| REQUEST | Current Zoning: R-22 MF, multi-family residential Proposed Zoning: UR-2 (CD) urban residential conditional and MUDD-O mixed-use development district optional. |
| LOCATION | Approximately 10.6 acres in the Grier Heights area, west of Ellington Street between Wendover Road and Billingsley Road. |
| SUMMARY OF PETITION | The petitioner is requesting a withdrawal of this petition. |

SCHEMATIC SITE PLAN

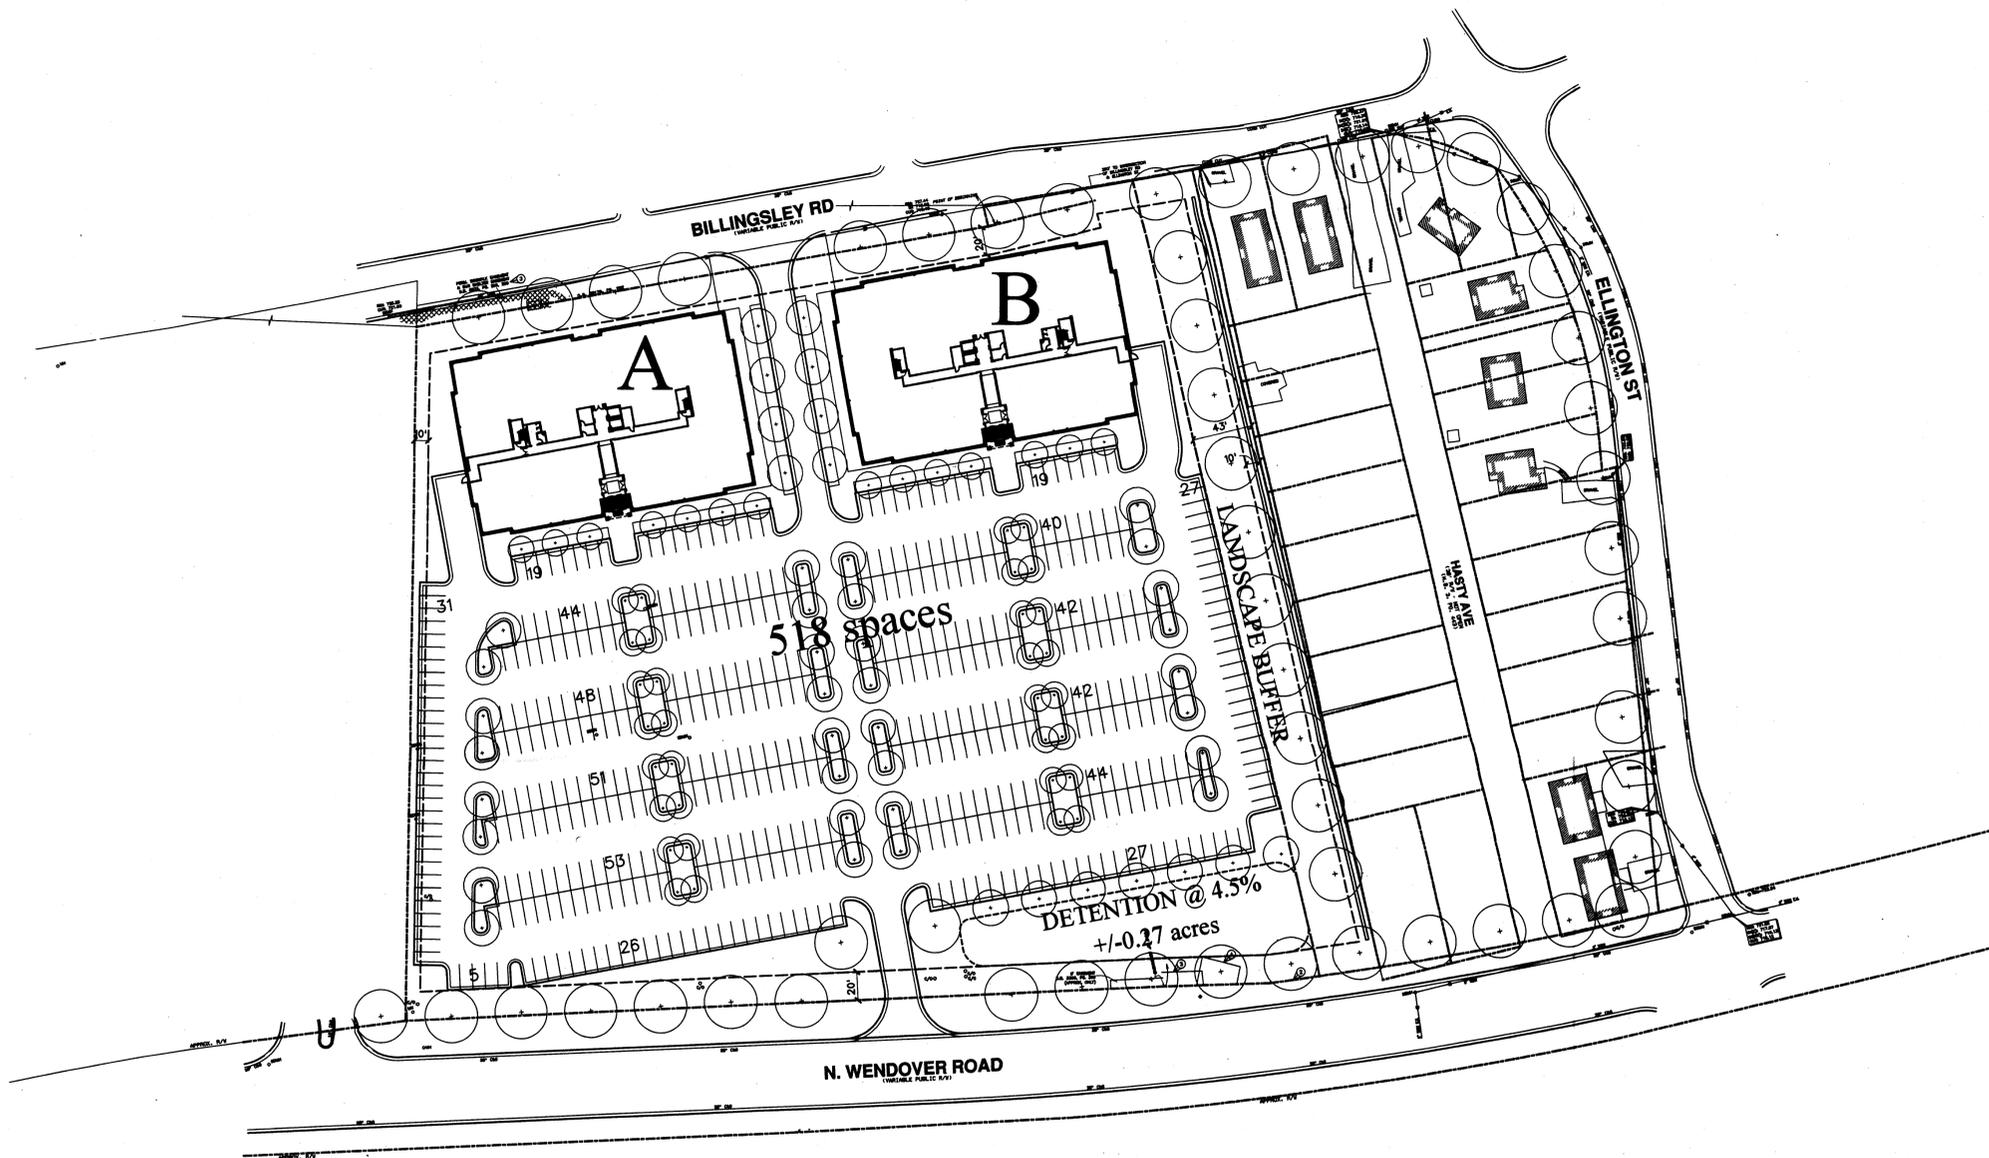
- **Vehicle Trip Generation**
Current Zoning: 1,600 trips per day
Proposed Zoning: 2,200 trips per day
- **CDOT:** CDOT will support only one connection (street or driveway) to Wendover Road to provide

access to the site. This access needs to be a public street in the location of the driveway shown at elevation +706 and connect Wendover Road with Billingsley Road. The current site plan has three access points on Wendover Road. The location noted by CDOT is currently proposed to be the entrance to a multi-level parking deck.
